SUBJECT: 5th & Marquette Office Building

REF: DRAINAGE PLAN FOR OFFICE BUILDING AT 5TH & MARQUETTE (J14-D44)
RECEIVED OCTOBER 22, 1984

RE: DRAINAGE PLAN FOR OFFICE BUILDING AT 5th AND MARQUETTE
(J14-D44)

REF: DRAINAGE REPORT FOR 5TH & MARQUETTE OFFICE BUILDING (J14-D44) RECEIVED
DECEMBER 3, 1984

DRAINAGE PLAN

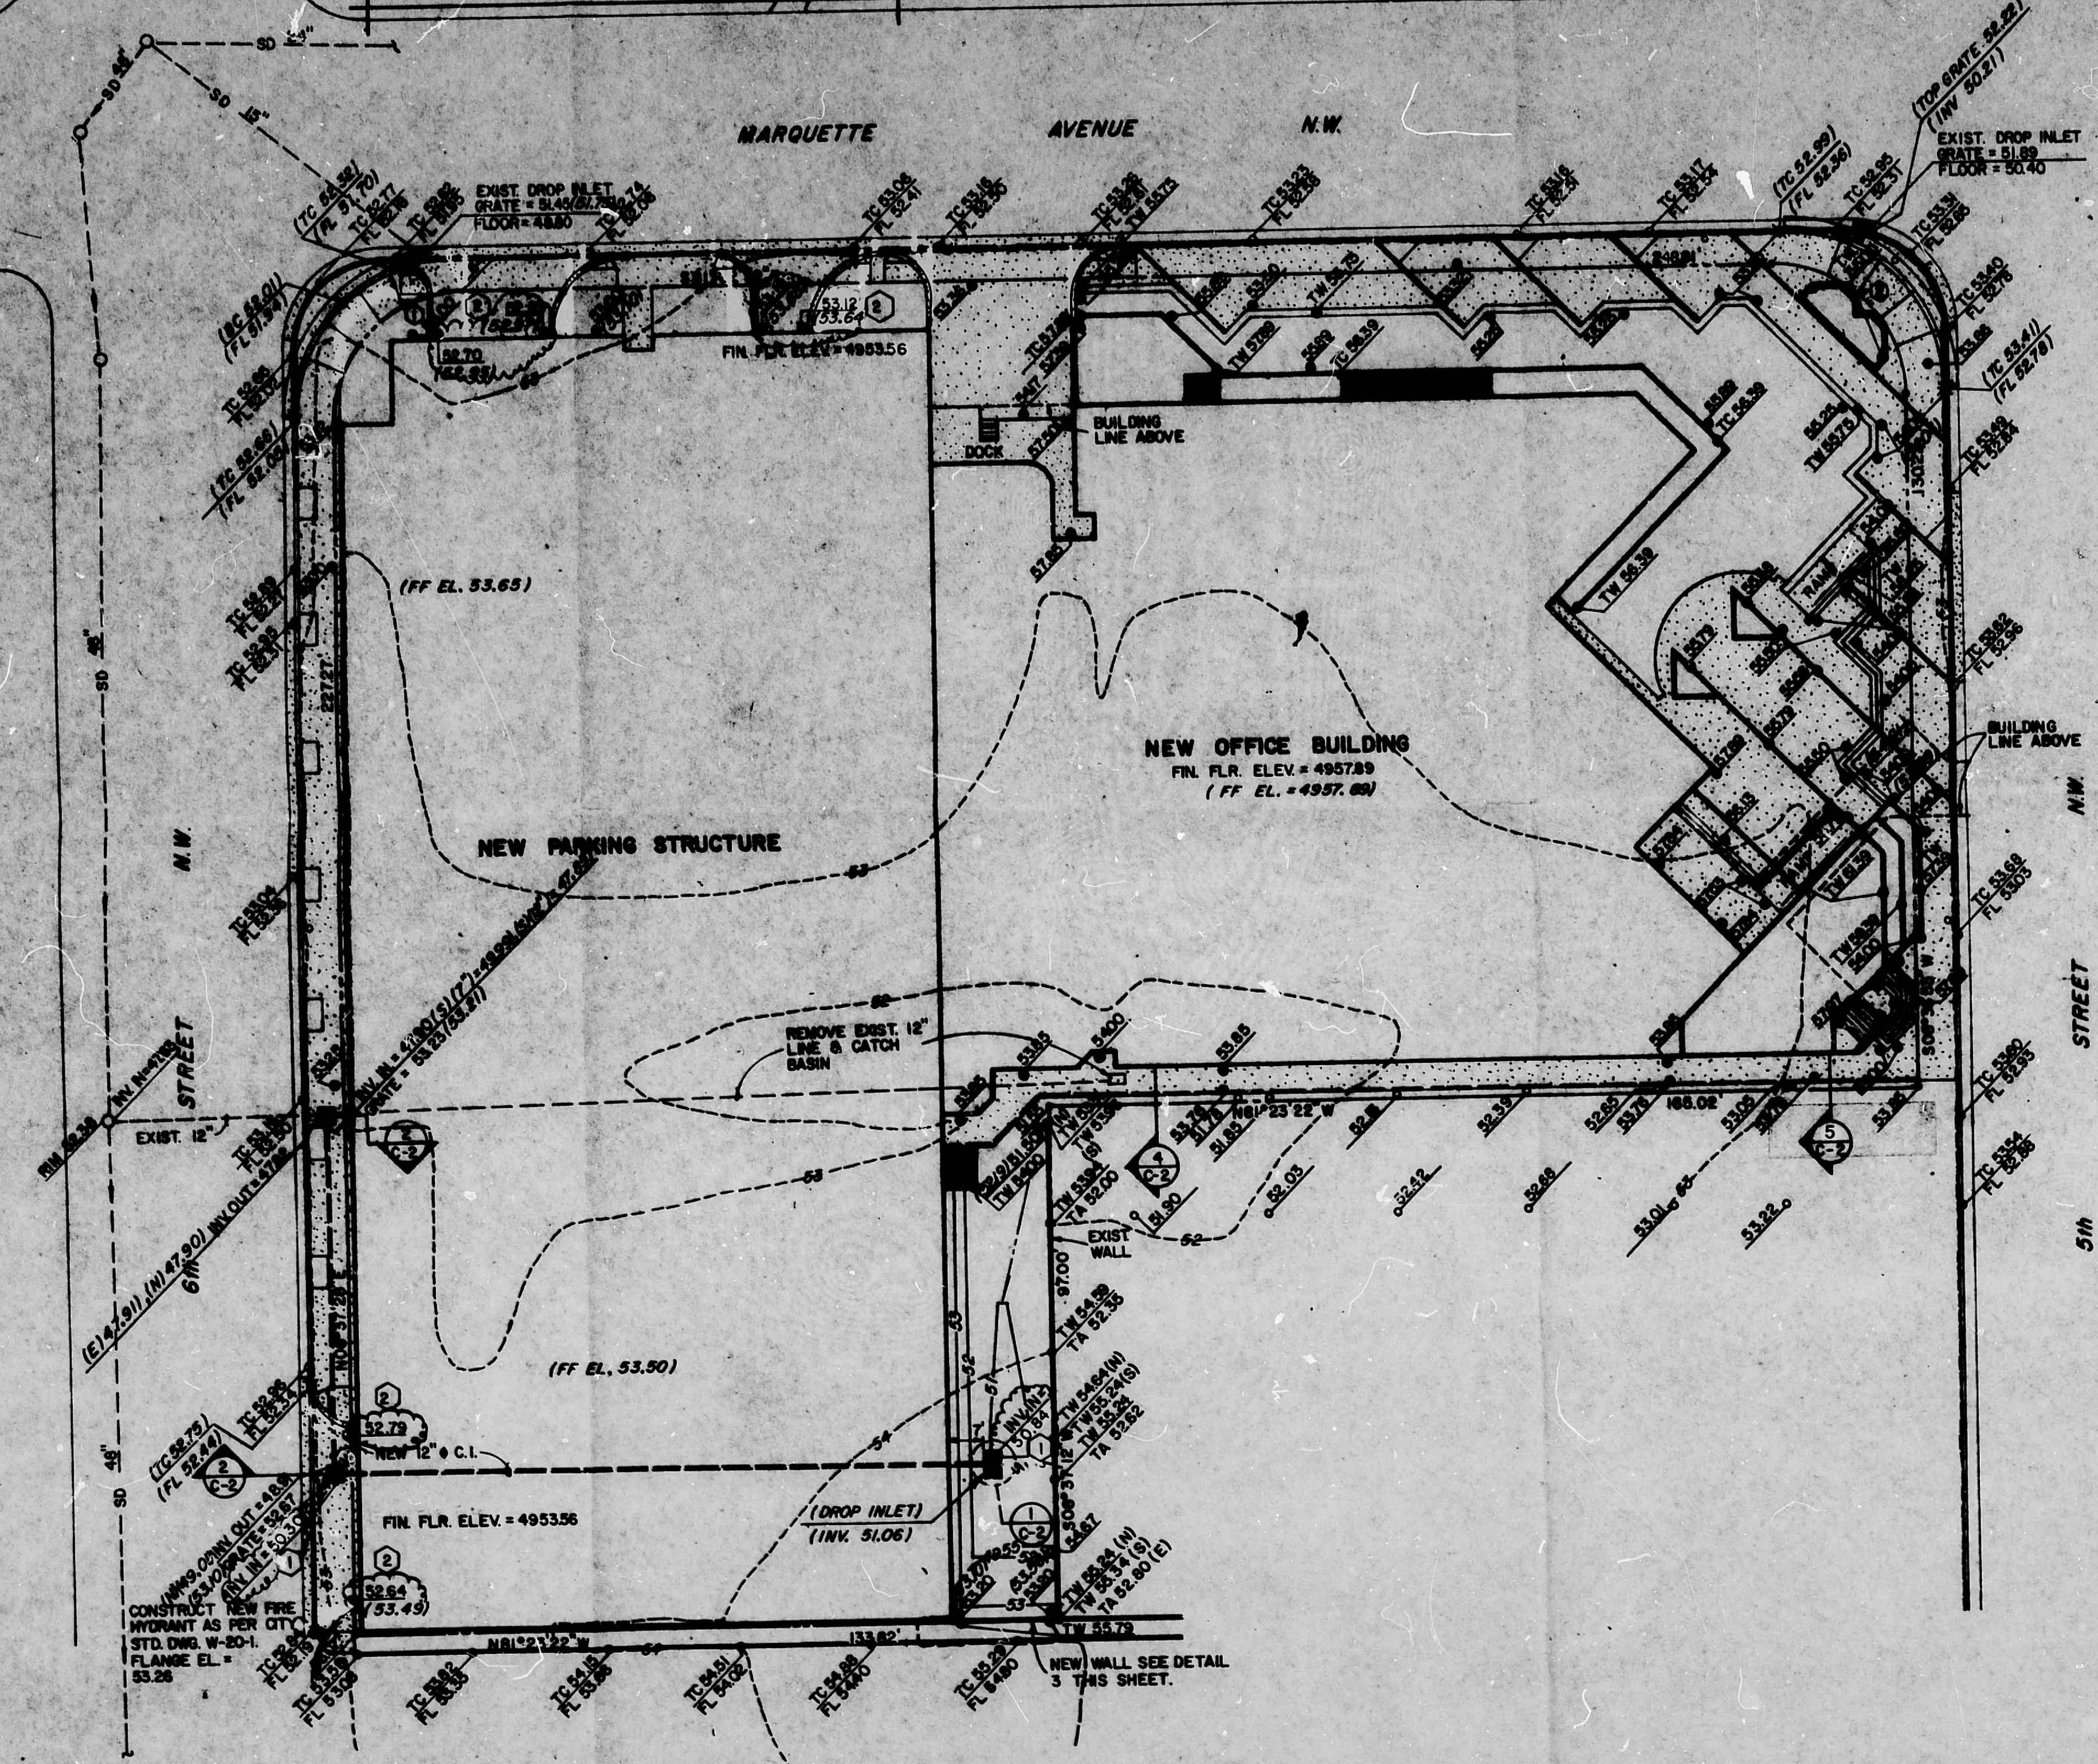
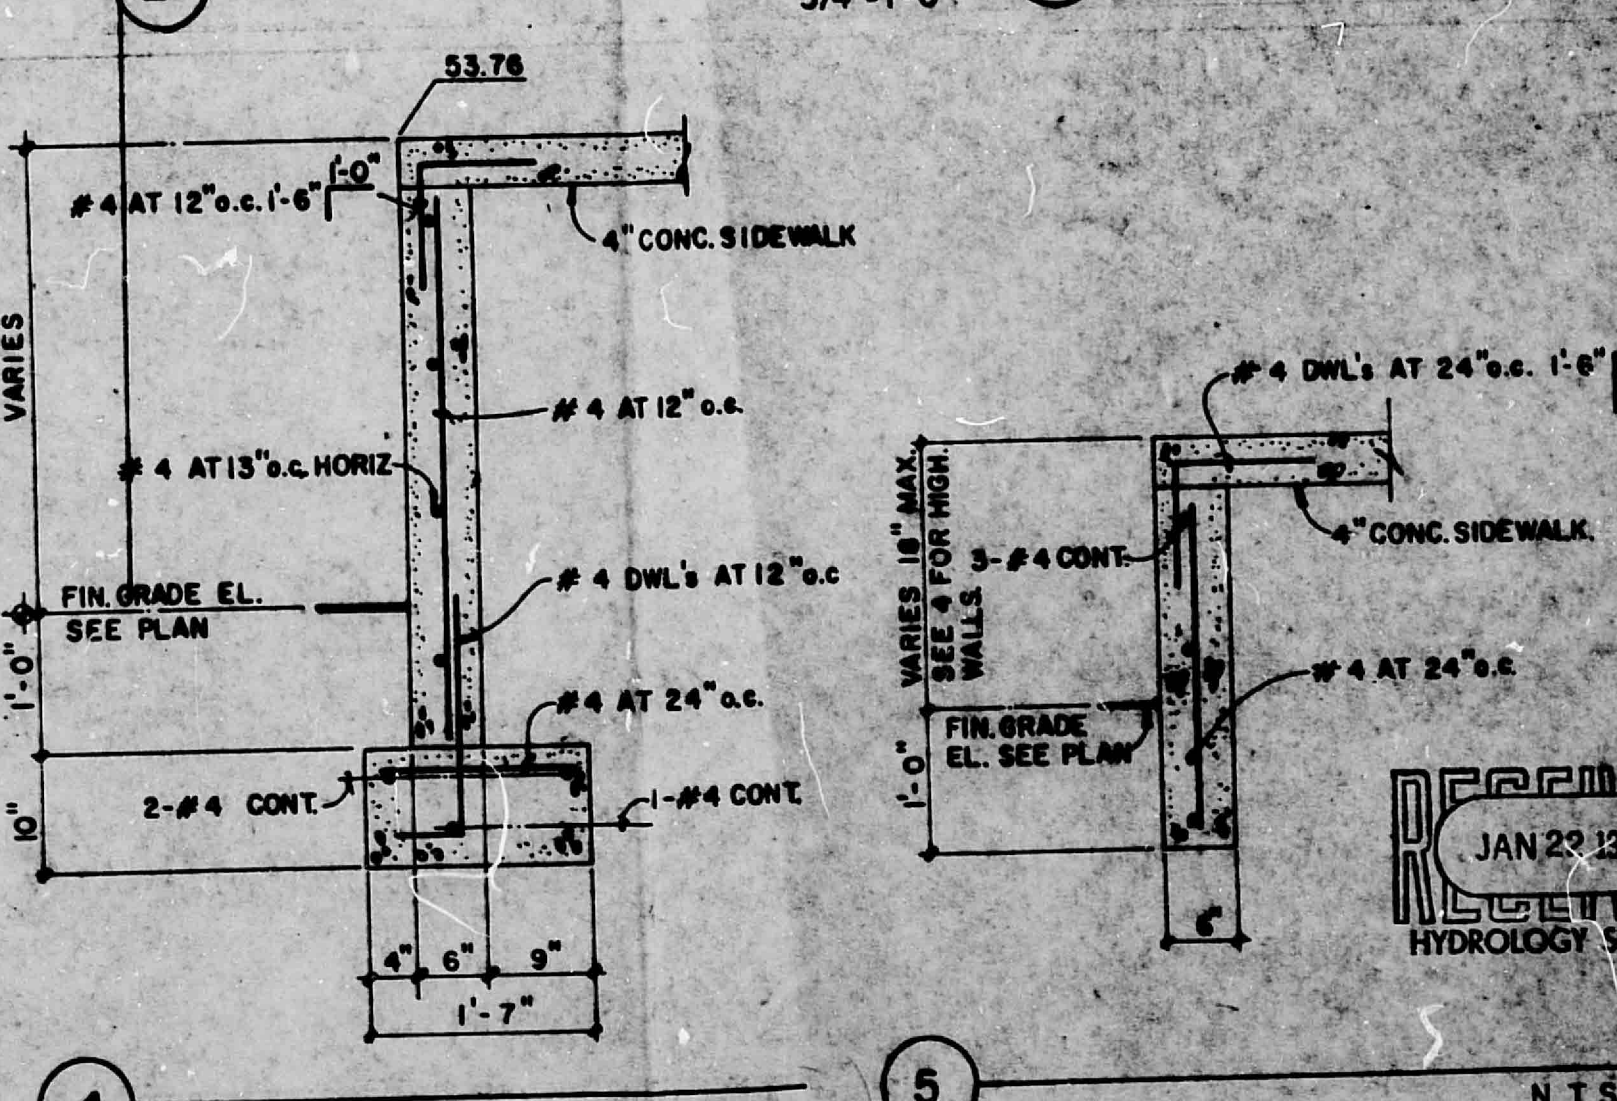
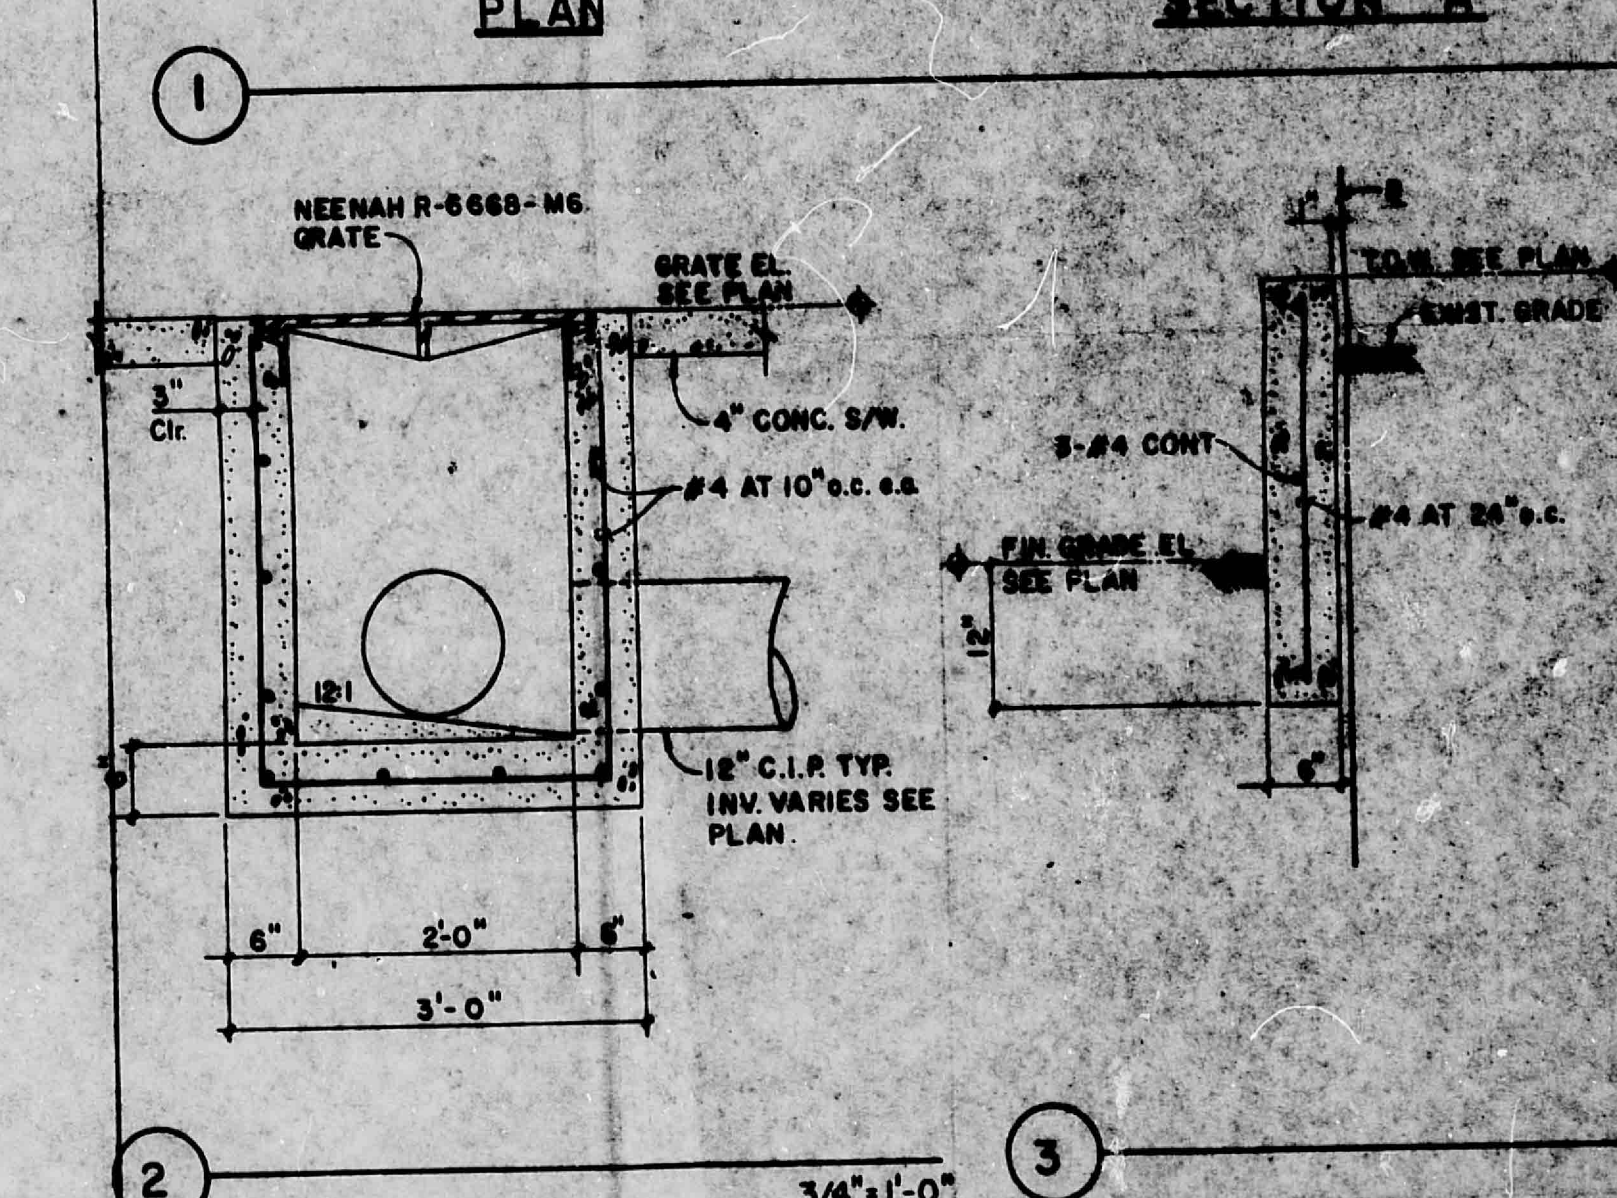
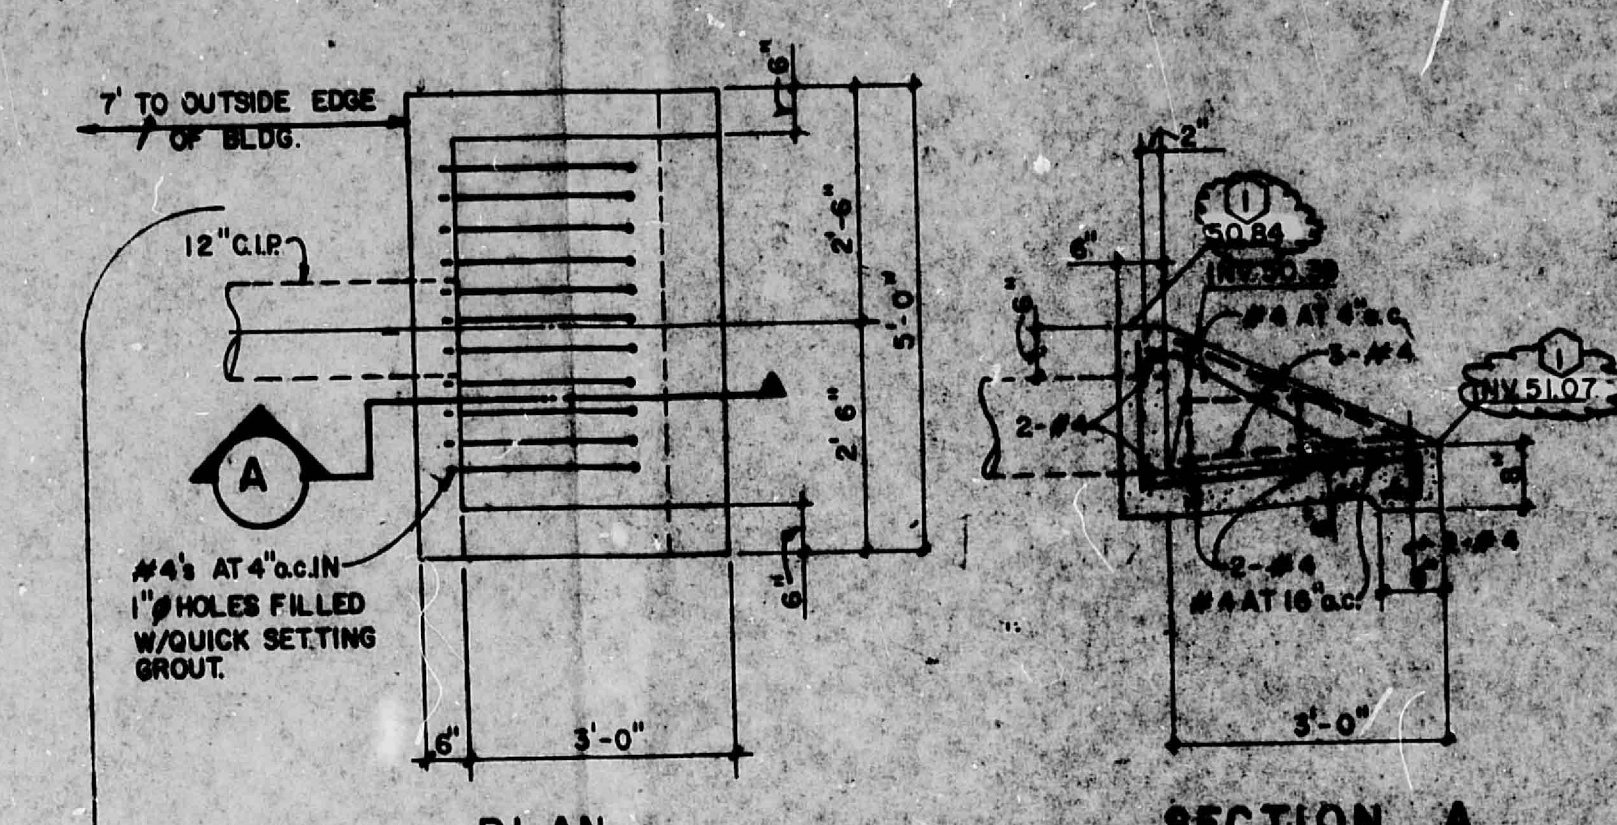
1. Please show how the off-site flows will be conveyed through the site.
2. Please review the top of wall and asphalt designation east of the new parking structure and west of the new office building.
3. Please show the hydraulic analysis for the new storm drain.

1. Off-site flows will be conveyed through the site by the existing grades. I have added additional off-site spot elevations to show this will occur.
2. The top of wall and asphalt elevations as shown are correct. The reason there are two top of wall elevations shown is that there are steps in the wall.
3. Analysis of the new storm drain is in the report submitted which was discussed in our meeting on November 29, 1984.
